Recommendation Report for Planning Permission for Works or Extension to a Dwelling

REF NO: LU/335/21/HH

LOCATION: 14 West Head
Littlehampton
BN17 6QP

PROPOSAL: Erection of self-contained annexe in rear following the demolition of existing rear shed.

Proposed Elevations

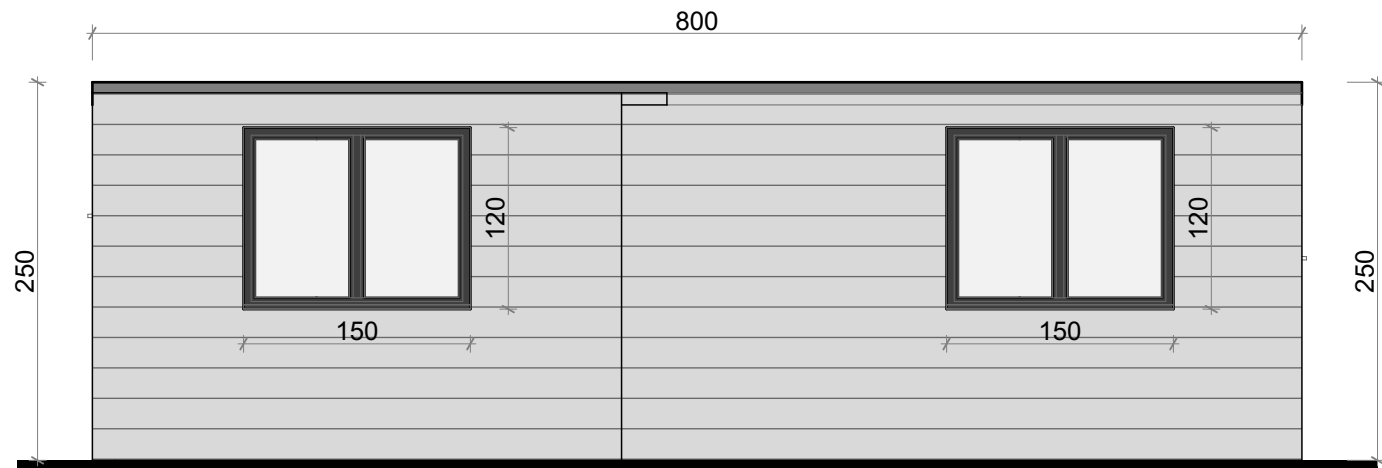
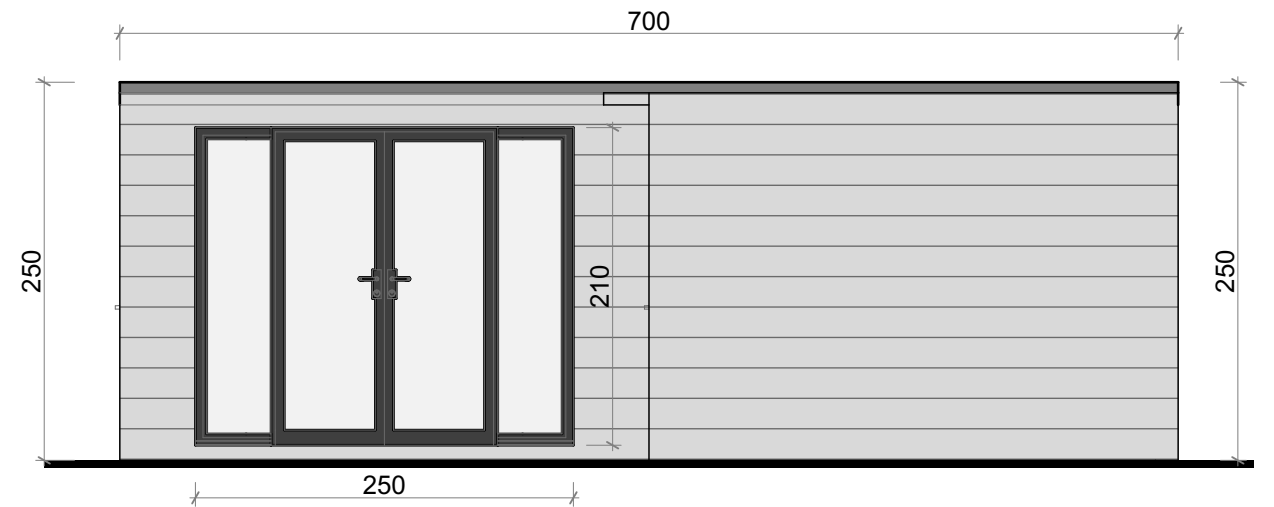
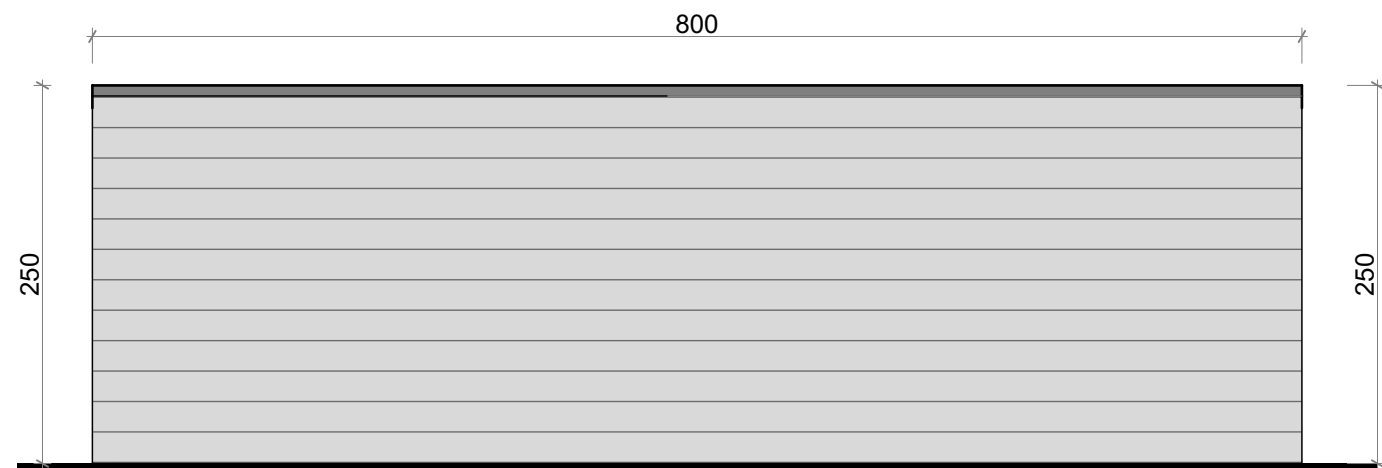
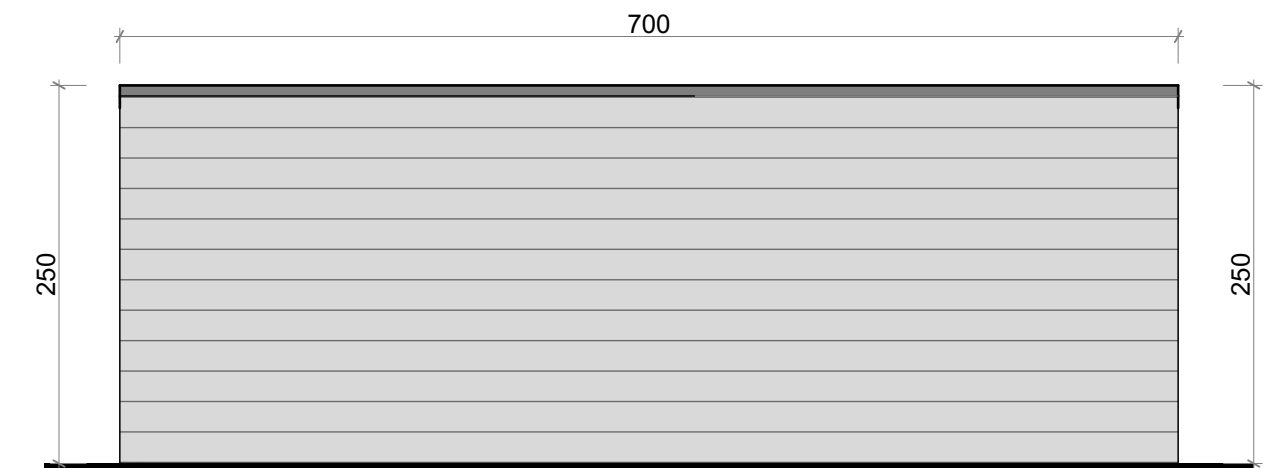
The building (at its widest points) will be 7m by 7m, single storey with a flat roof. The outbuilding will be accommodated within the rear garden in place of a shed. The outbuilding will not alter the established spatial character of the area nor be visible from the street.

All proposed fenestration will be positioned to have views towards the centre of the site, back towards the main house. These will be located at ground floor level and therefore no negative impact from overlooking is foreseen.

Being a low level single storey building with a flat roof its maximum height will only be 700mm higher than fence lines, it has also been design to be a minimum of 750mm away from boundaries, it is therefore considered not to overbear or overshadow neighbouring properties amenity space.

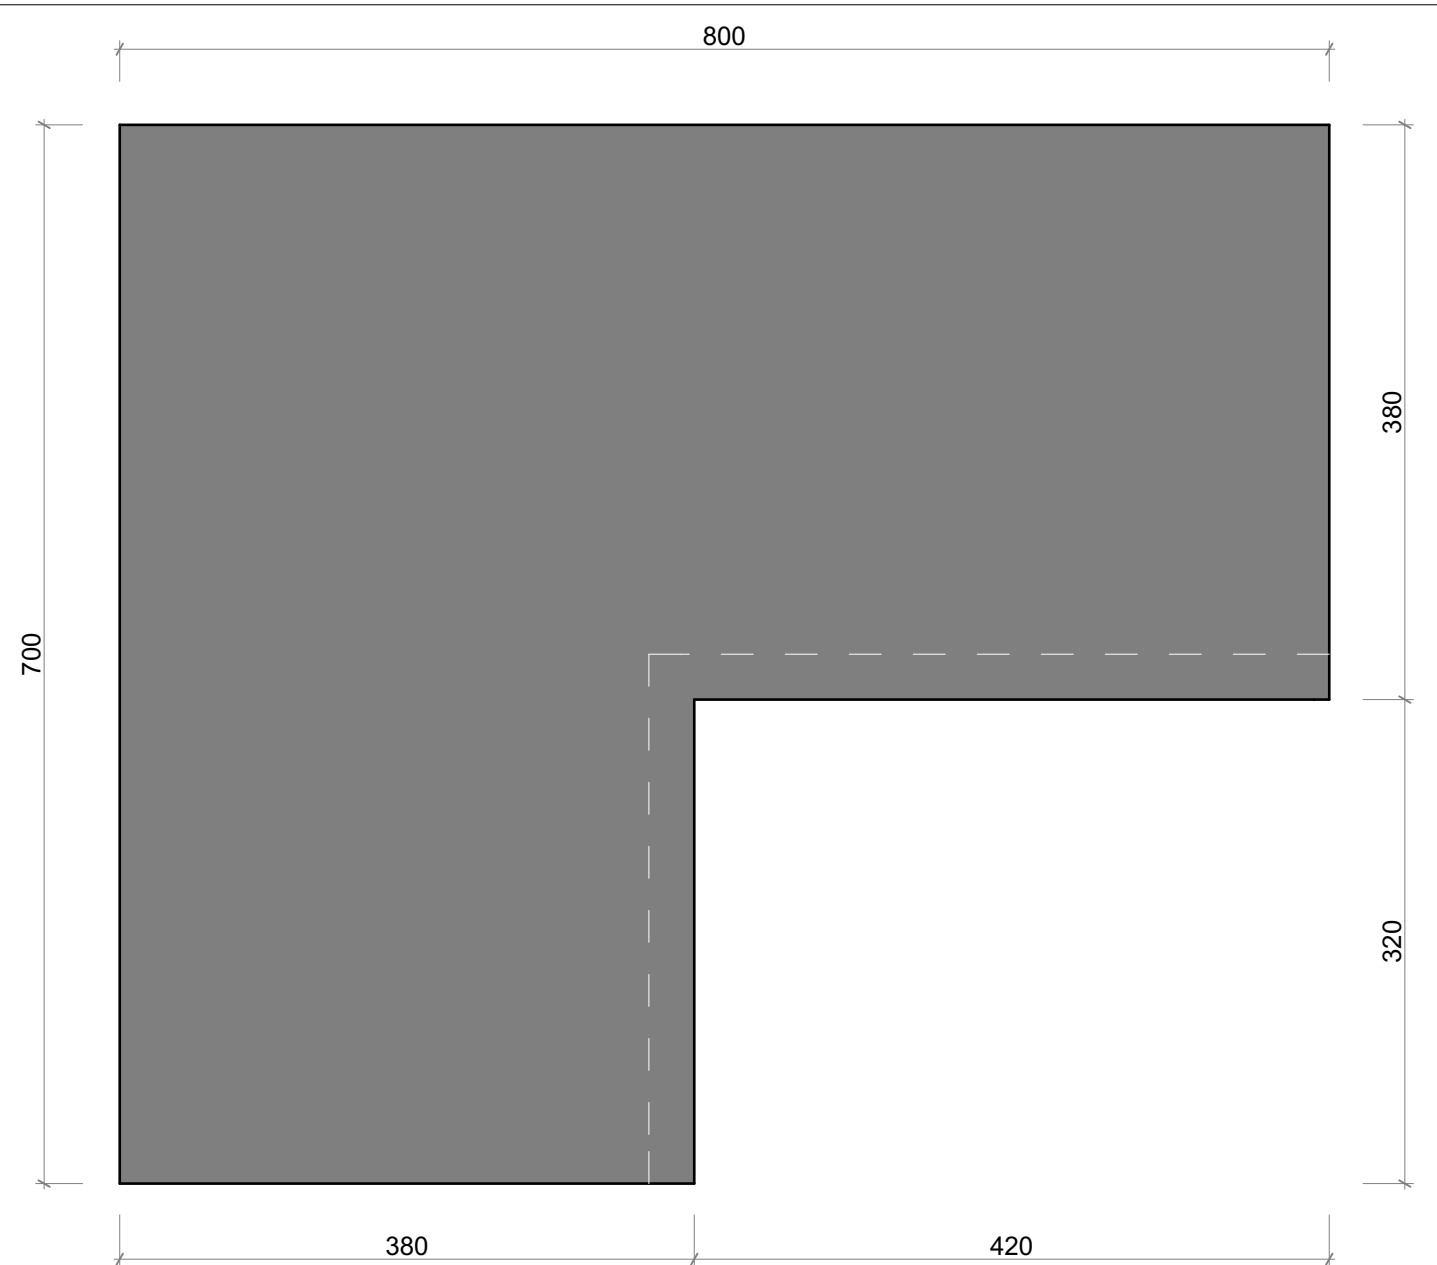
It is proposed to construct an 'L' shaped detached annex building for use by family members in connection with the main dwelling. The occupants will co-exist between the outbuilding and the main dwelling.
